Anastasia Kistaou
La Casita, Wessex Avenue, Bognor Regis

Your Ref: OWPC16723
Our Ref: AW/328/17/OUT 30-10-2017
Please ask for:
Mr S Davis

Outline application with some matters reserved for the conversion of existing dwelling into 5 self contained flats with front, rear, side & dormer extensions (resubmission following AW/71/17/OUT).

14 Princess Avenue Aldwick

Proposed Second
Floor Plan

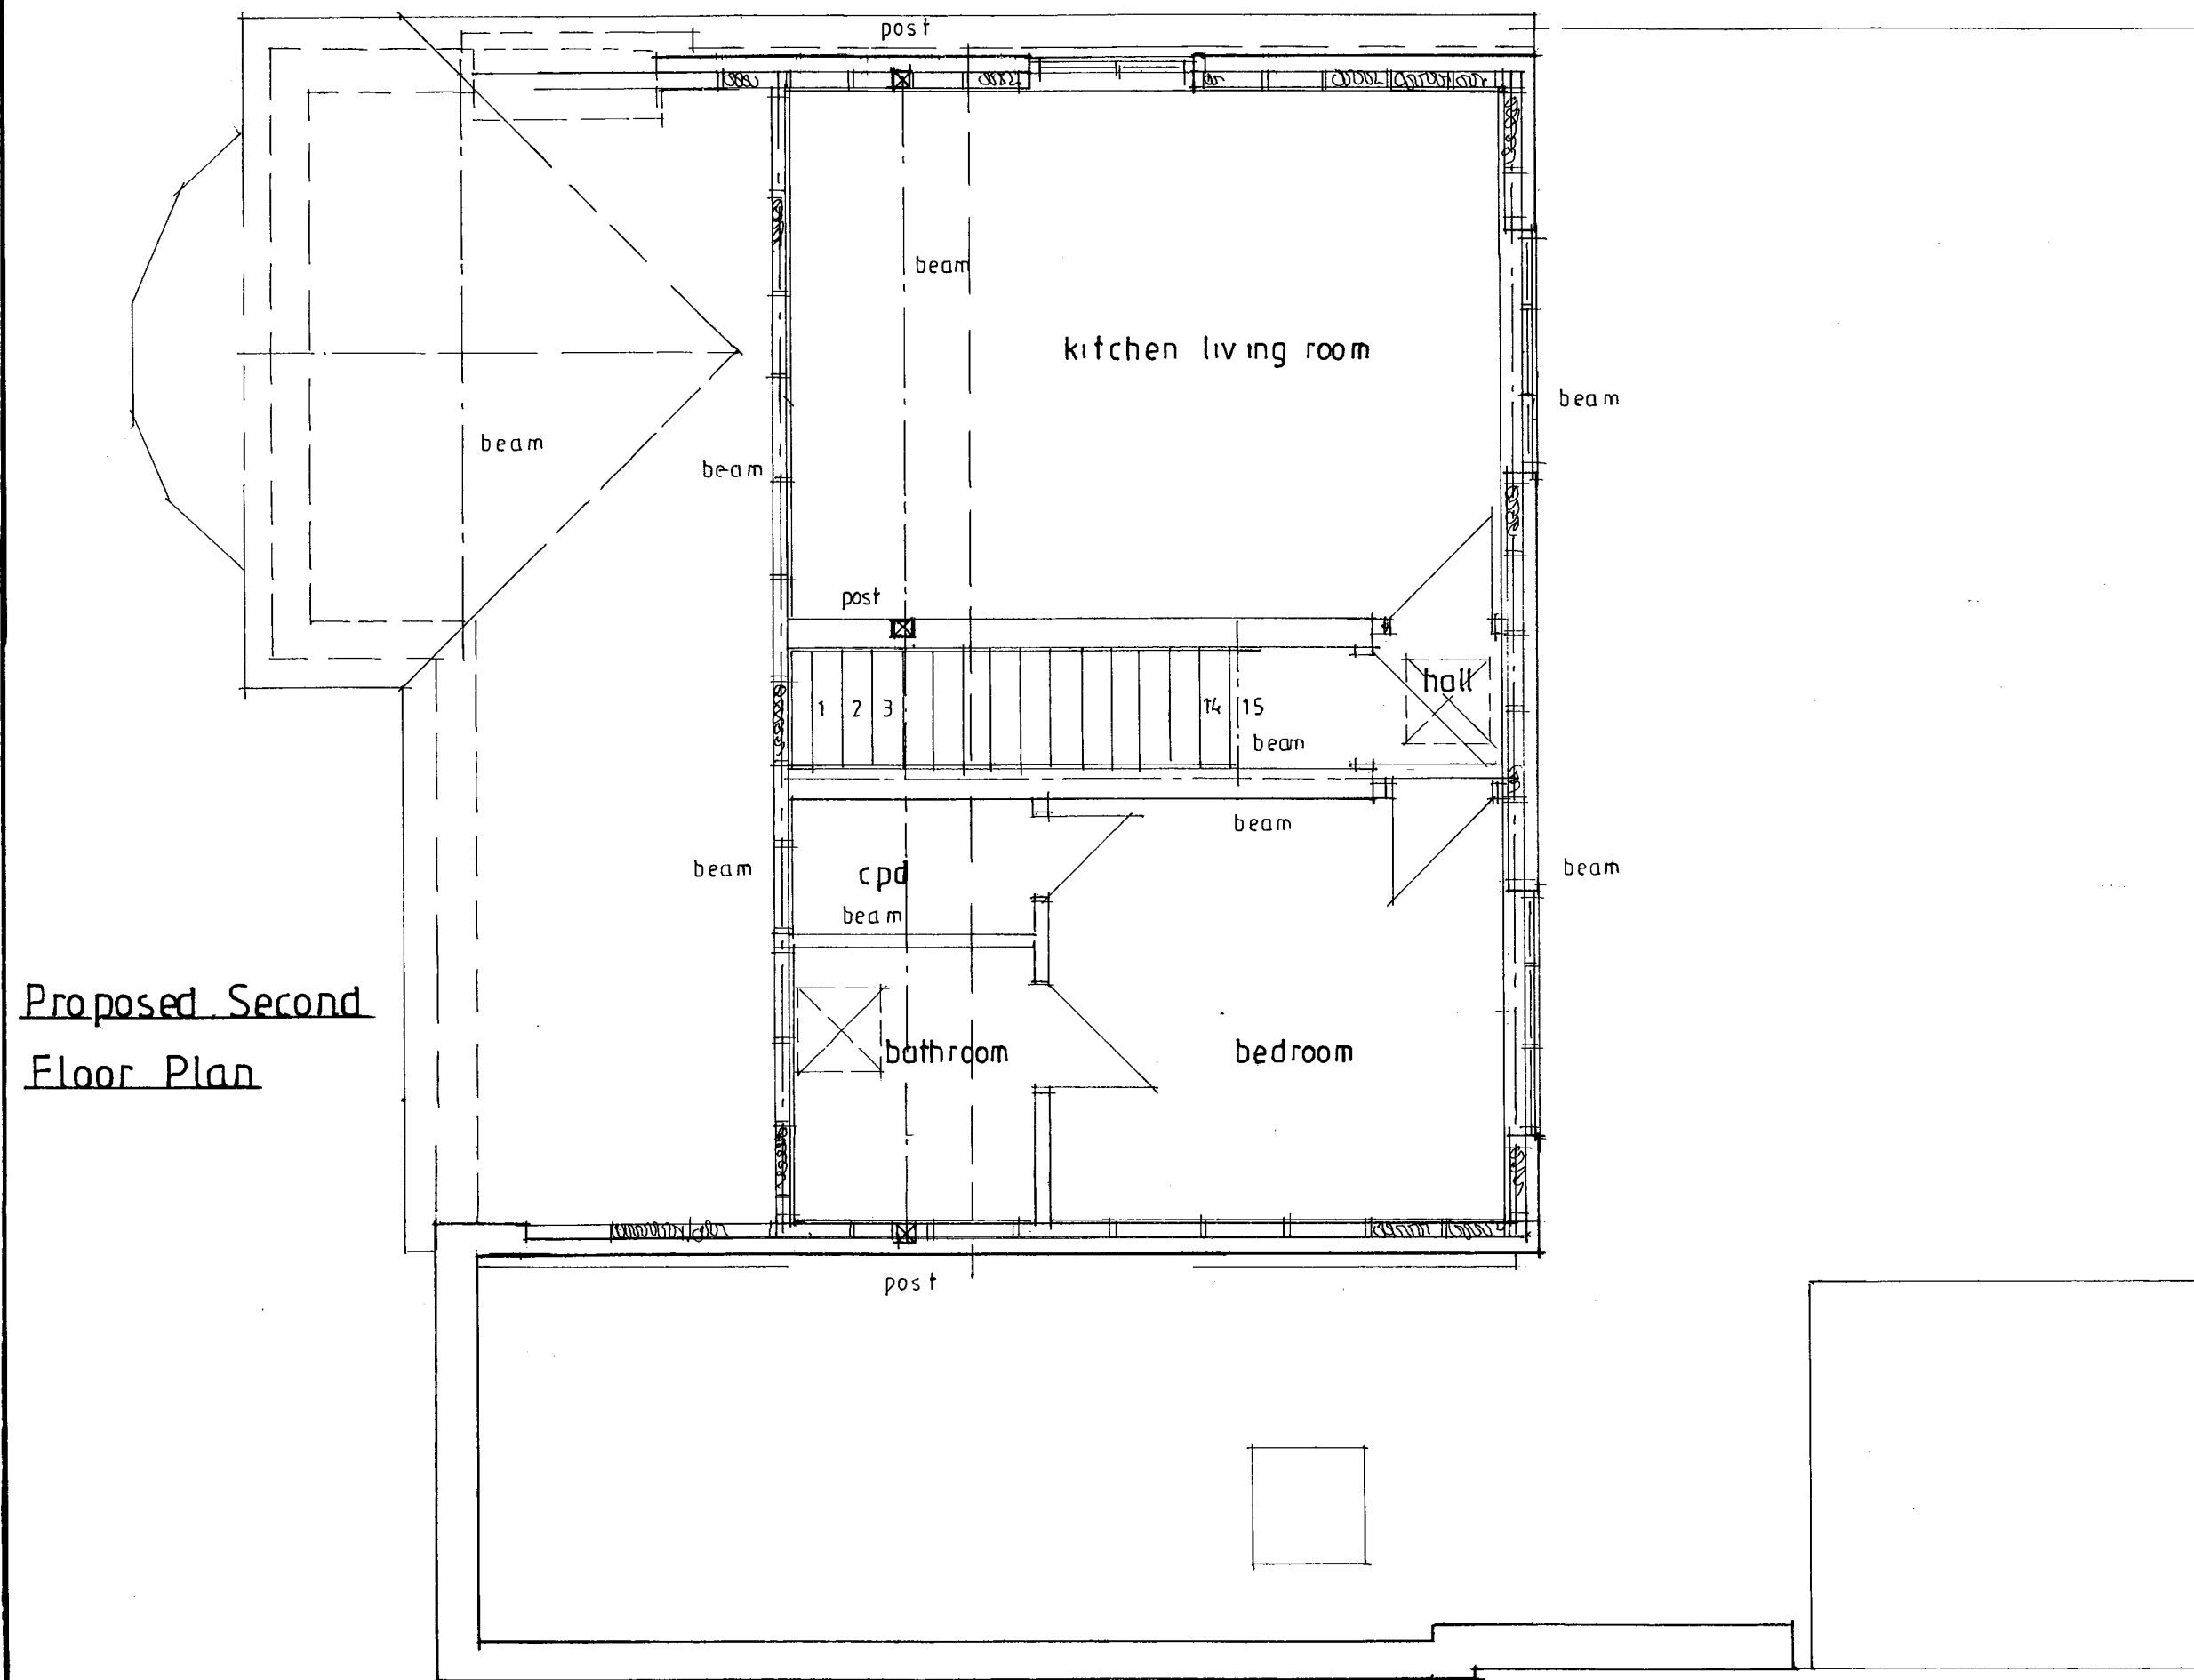
Firstly I'd like to talk about the point of privacy for me and My son who are both residents at La Casita, the planning permission will greatly decrease the solitude of our home; the extension on the house in question will increase the height and point of view of the residents to come which is incredibly concerning. Not only will they have a clear view of my garden they will have a view of my bedroom which I'm sure you can agree, would be unnerving to see potential people looking into my window. In regards to people seeing into my garden it may drive me to not host social occasions for my friends and family as to not be invaded by on lookers. This could conclude in me not being able to see my family as much as I'd like especially in the hard time that I find myself in; My husband sadly passed away very recently and I'm still very much raw and hurt by the situation, not to mention that other members of my family have also sadly passed. The time I find myself in, it's essential I have the ability to feel safe, reassured and secluded in my house that means so much to me and even more so to my husband.

**Proposed Flat Conversion.
Cycle & Bin Store.**

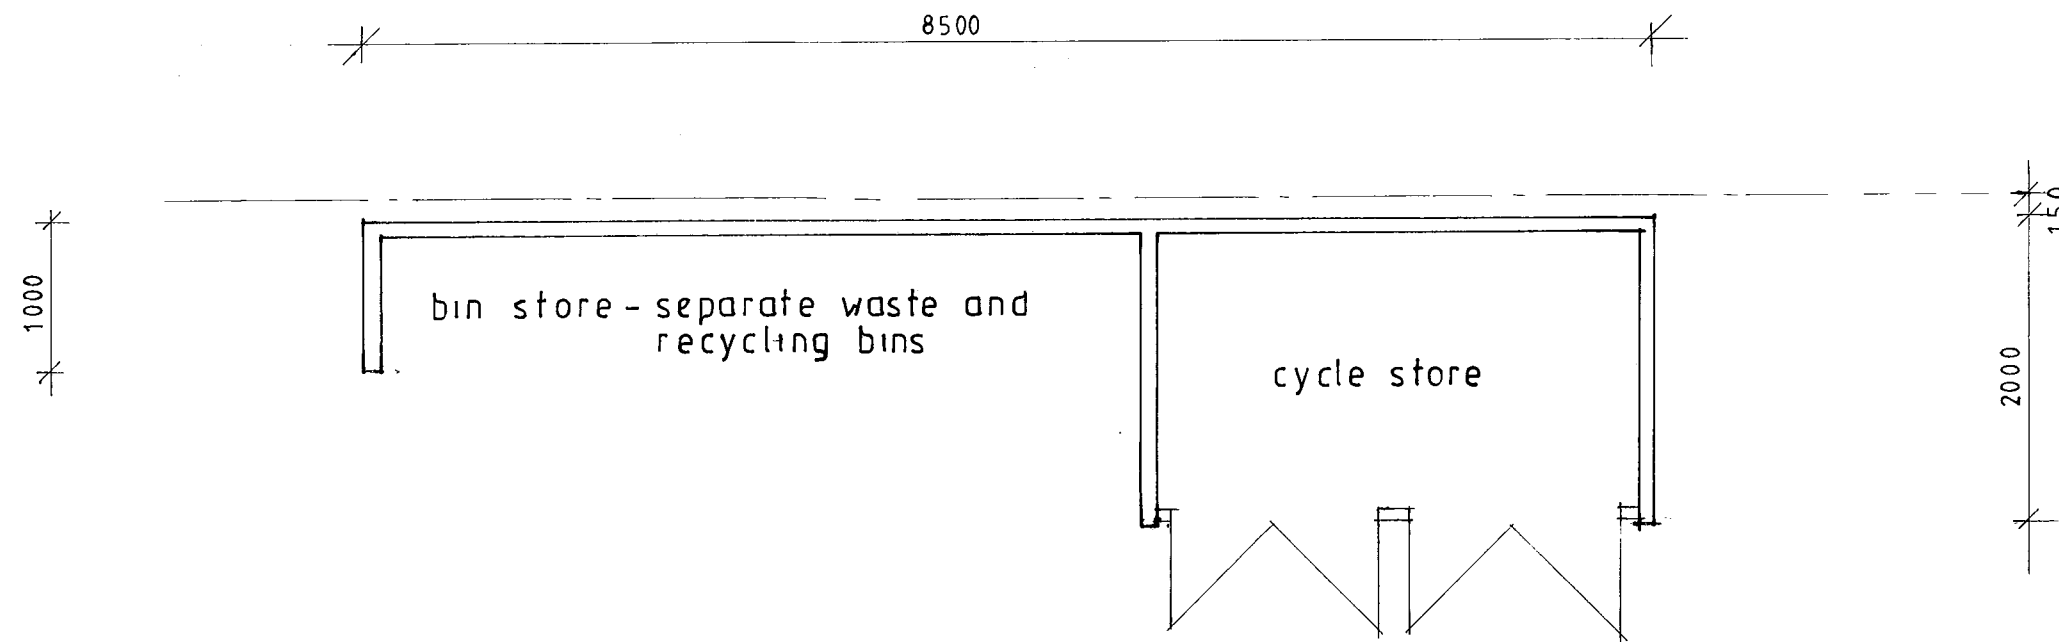
After inspection at the planning permission it is clear that the bins of the house/flat in question will be next to our rear garden wall. It is quite obvious to assume that the smell from those bins will hit my garden and indeed my house, this could mean that I wouldn't be able to open my doors in the summer and have to deal with excruciating heat, Nor will I be able to enjoy the pleasant weather in summer. My quality of life and standard of living will be greatly affected if said planning permission was to take place, and I strongly object to them. In my time of grief I need solitude and privacy and the need to not change the way I live my life now.
